March 24, 2023

**RE: Sawmill Tract H, 1921 Bellamah Ave. NW**  
**Grading & Drainage Plan**  
**Engineer's Stamp Date: 3/23/2023**  
**Hydrology File: J13D017B**

**RE: SAWMILL TRACT H, 1921 BELLAMAH AVE. NW  
GRADING & DRAINAGE PLAN  
HYDROLOGY RESPONSE TO COMMENT**

| |  | SHEET # GR-1 |

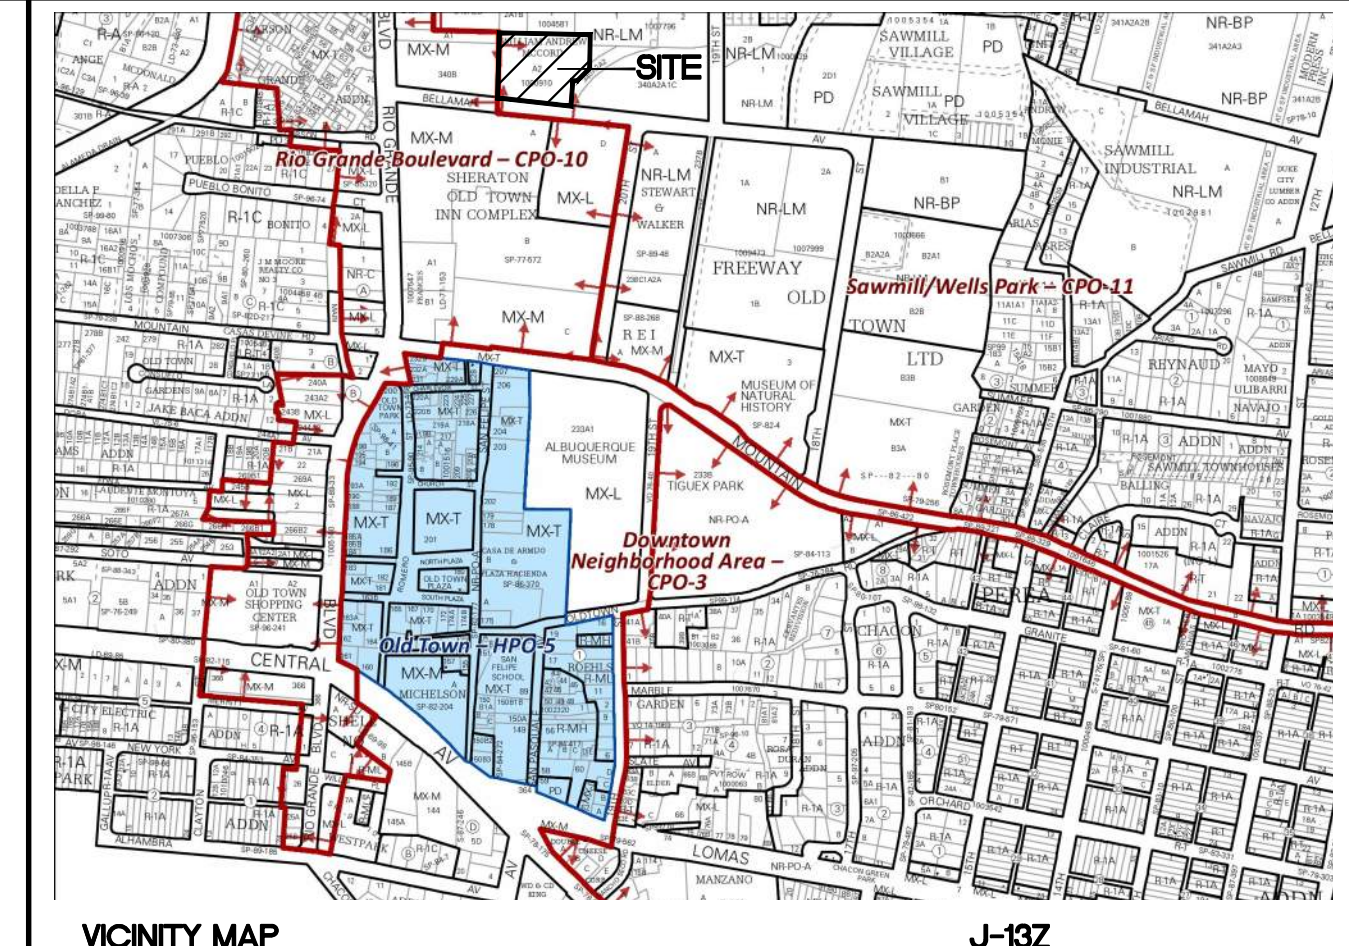
1. Please provide pond 2 location, volume, and cross-section on sheet #GR-1.  
**That was a left over sentence from a previous concept. That paragraph was removed and the narrative updated to reflect the current drainage.**

2. Show the bioswale for proposed basin 1.  
**The bioswale is along the north property line and is now labeled.**
3. On sheet #GR-1, Proposed Drainage: It states that "The pond in basin 2 will retain the developed runoff of 0.036 ac-ft which is less than the required water quality volume of 0.40 ac-ft". – This statement is confusing. First of all, the retention pond volume should not be less than the SWQV. Secondly, would pond 1 volume be counted for part of the SWQV? Please clarify. Also, the required SWQV is 0.04 ac-ft, not 0.40 ac-ft. This might be a typo.

**The narrative was updated to provide a clearer picture of the drainage and calculations**
4. On the same sheet: The next sentence states that "The pond will drain 7.15 cfs. Therefore the total discharge from the site will be 8.09 cfs". – Please provide calculations showing that where these numbers come from.

**A pond volume table was added to the Drainage Plan showing the calculations.**
